Re: Section 73 Variation of condition application to planning consent SDNP/22/05710/FUL dated 18th May 2023– Erection of 20 pre-fabricated glamping pods and associated footpaths, retrospective alterations to previously consented raised timber decking adjacent to driving range with addition of pergola and associated alterations, and erection of pergolas over clubhouse rear patio at: Blacknest Golf & Country Club, Frith End Road, Blacknest, GU34 4QL

Please find enclosed a section 73 Variation of Condition application for minor material amendments to planning consent SDNP/22/05710/FUL.

EV CHARGING POINT PLAN & ELEVATIONS - Scale 1:20 @ A1

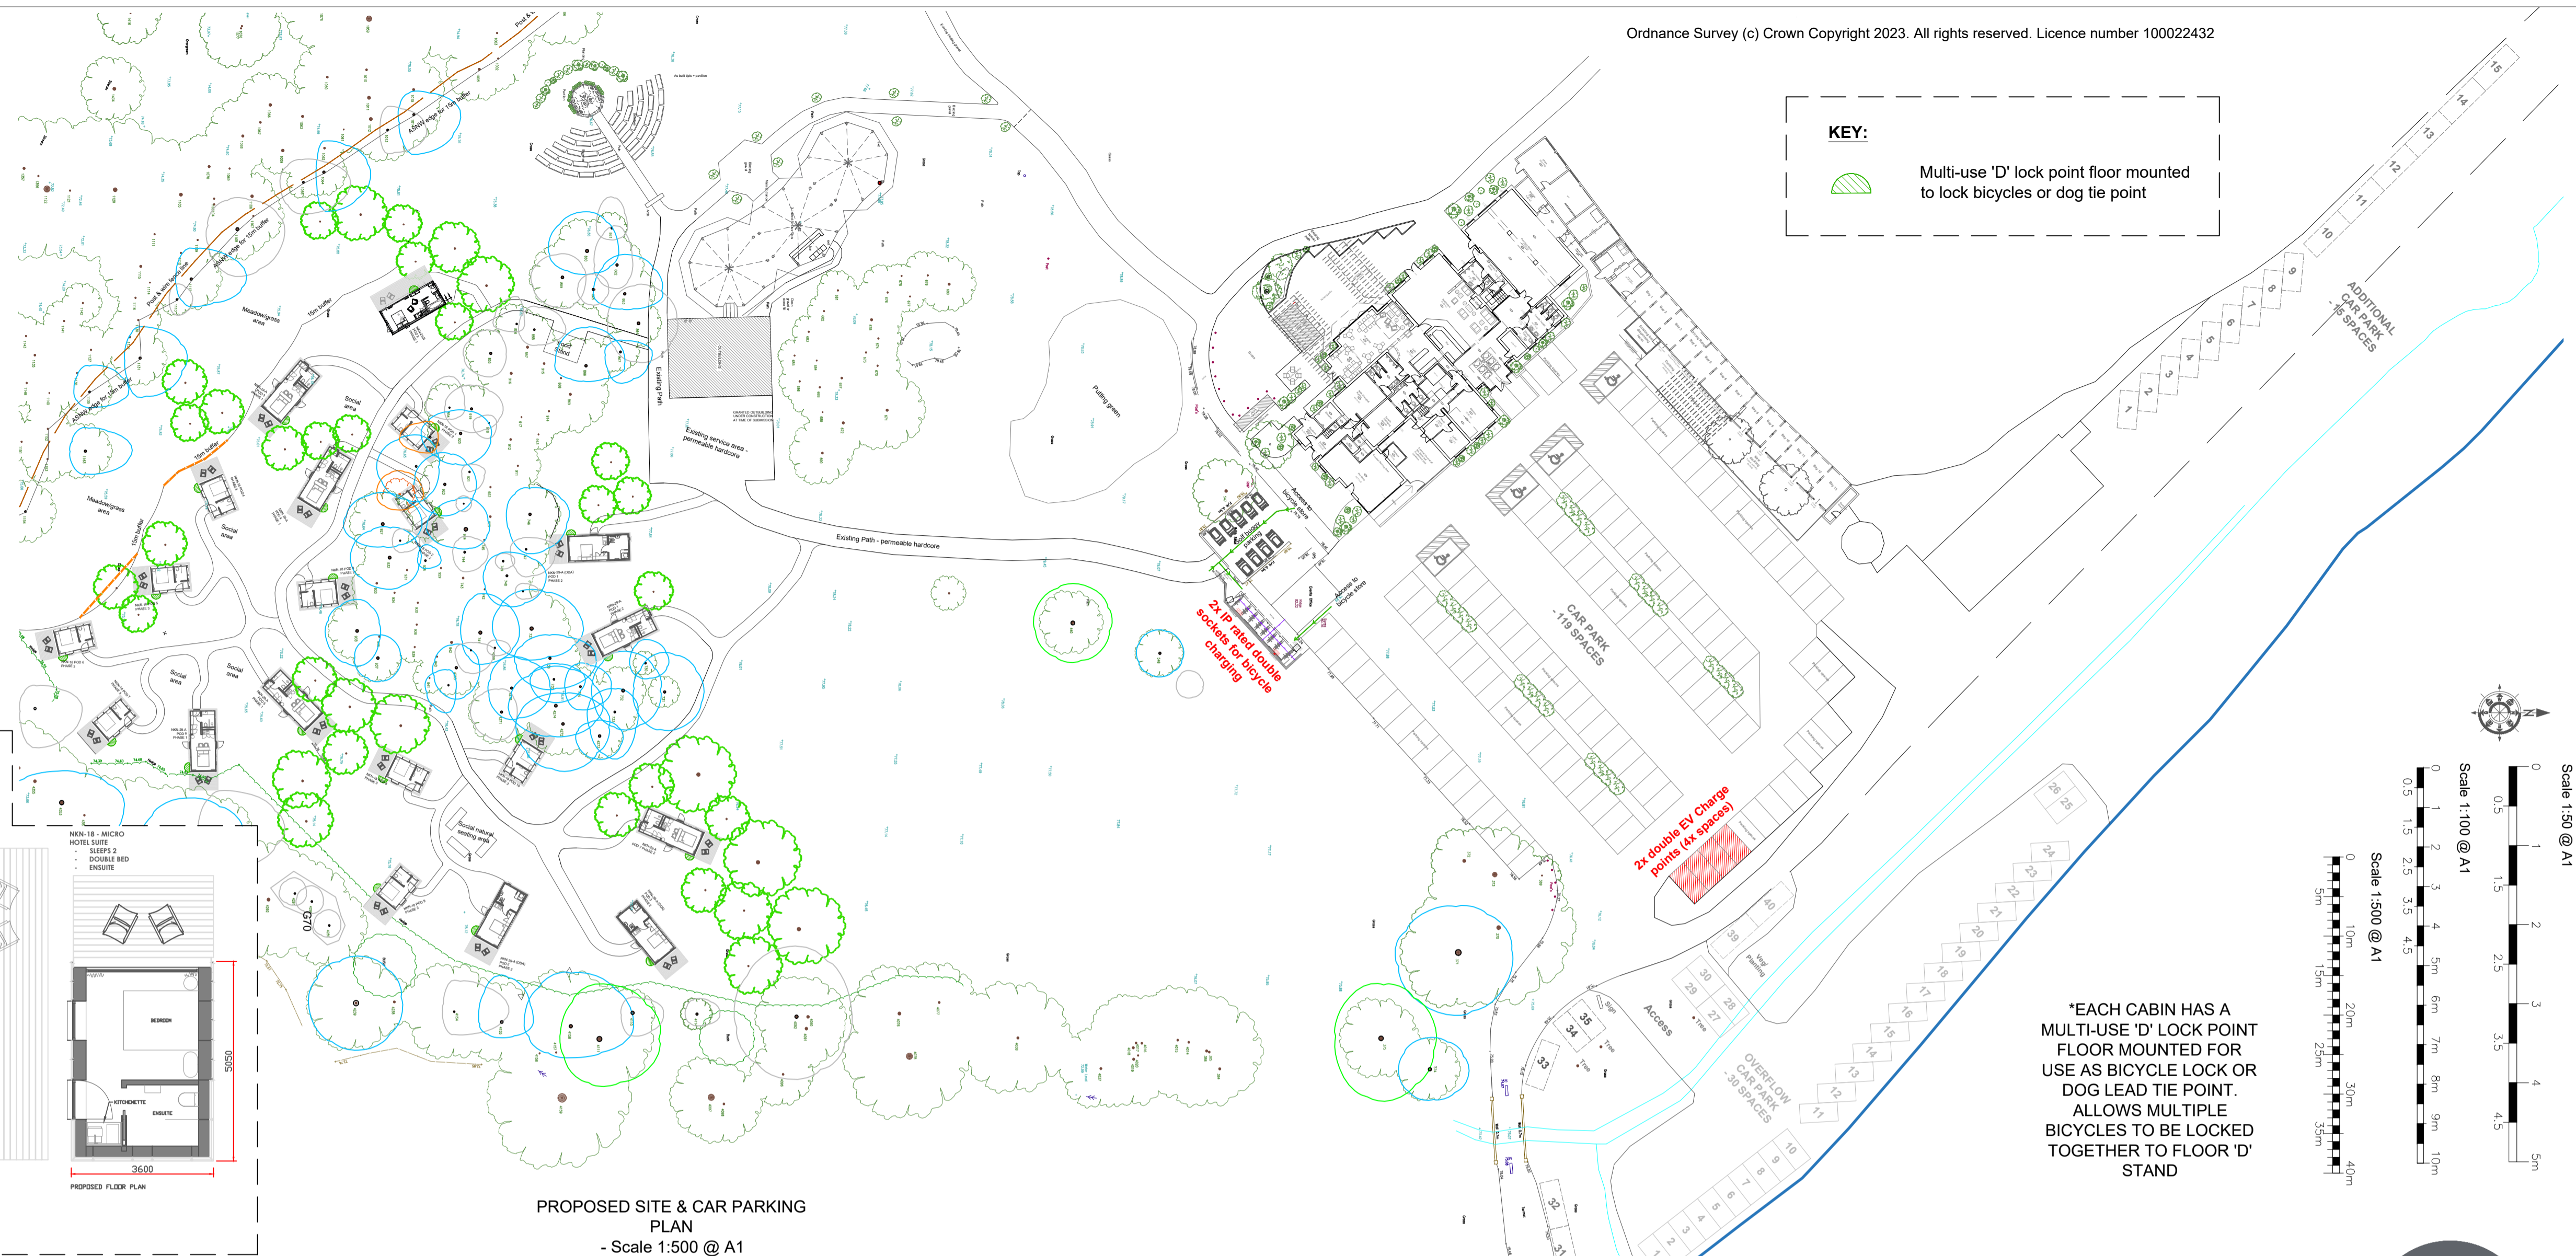
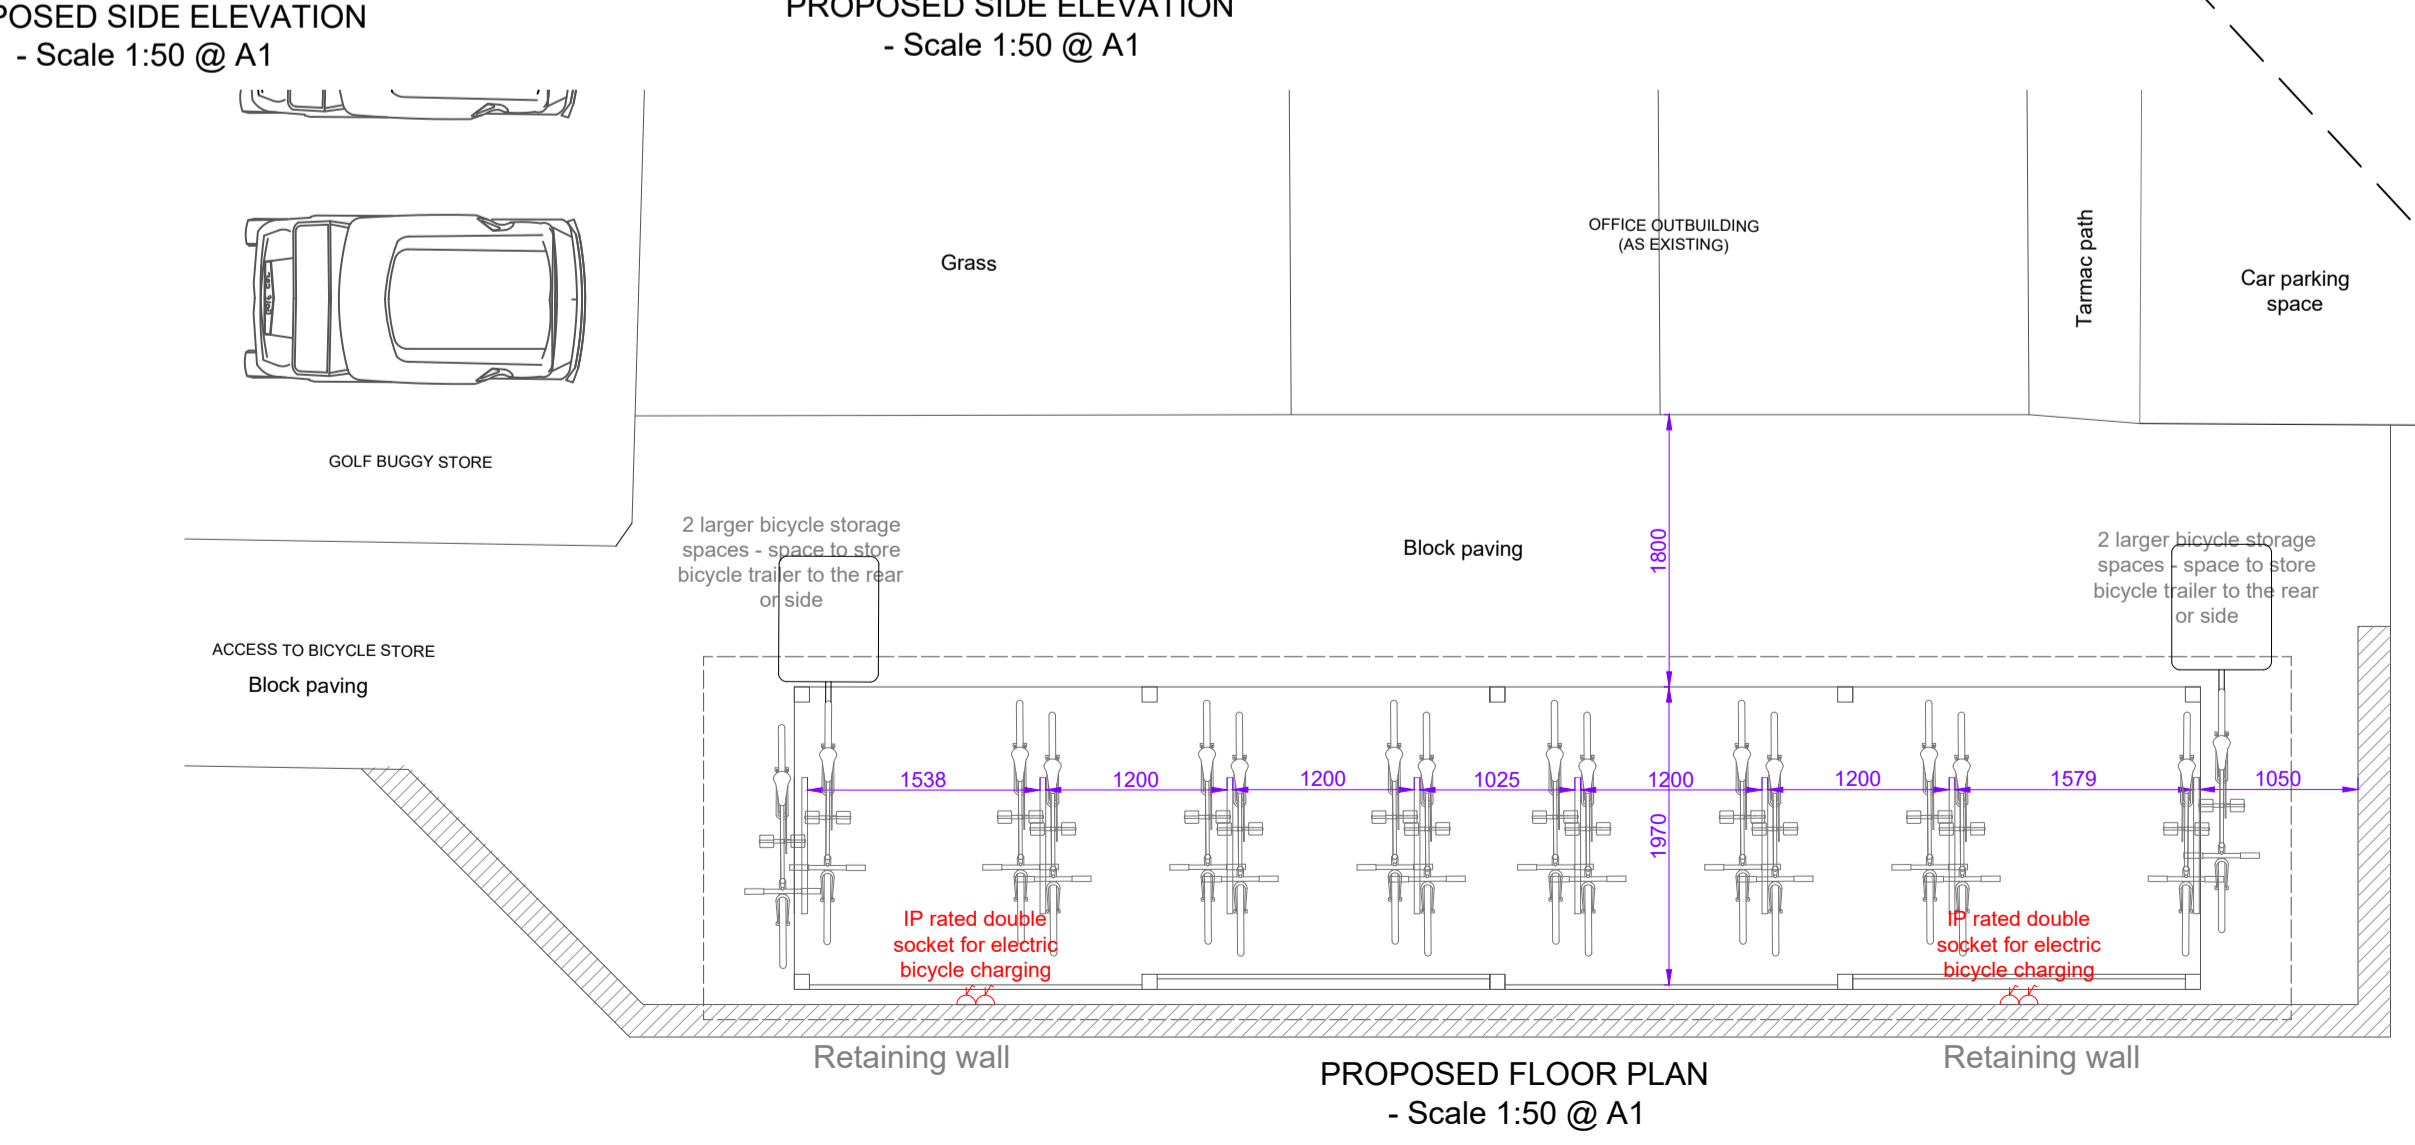
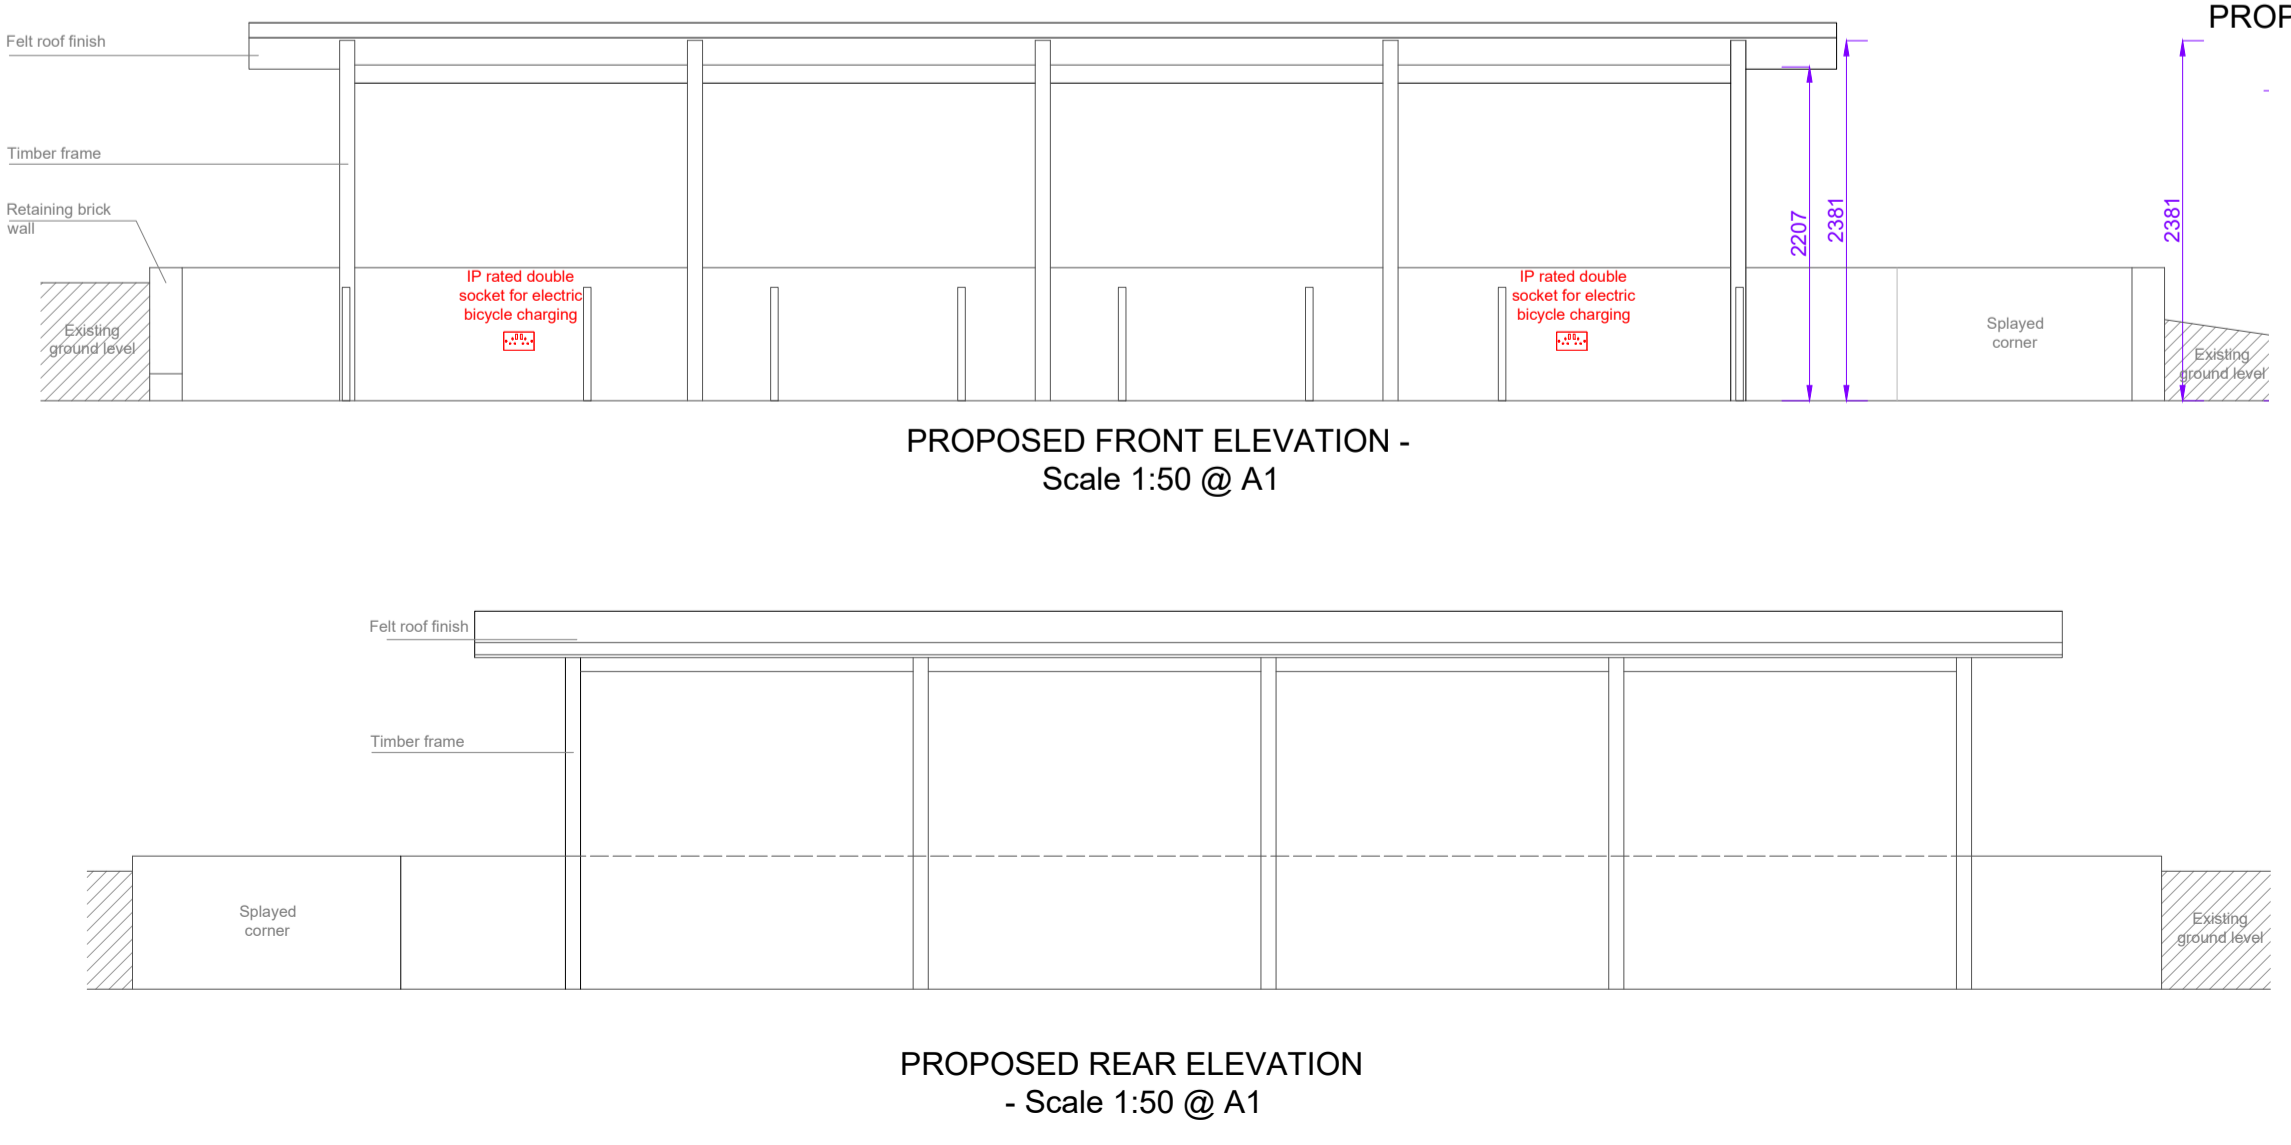
- Request to vary the condition wording to take consideration of the phasing of installation of the cabins. Requested to amend the requirements for the EV vehicle and bicycle facilities by the clubhouse to be a phased install, preferably all to be undertaken as part of installing phase 3.
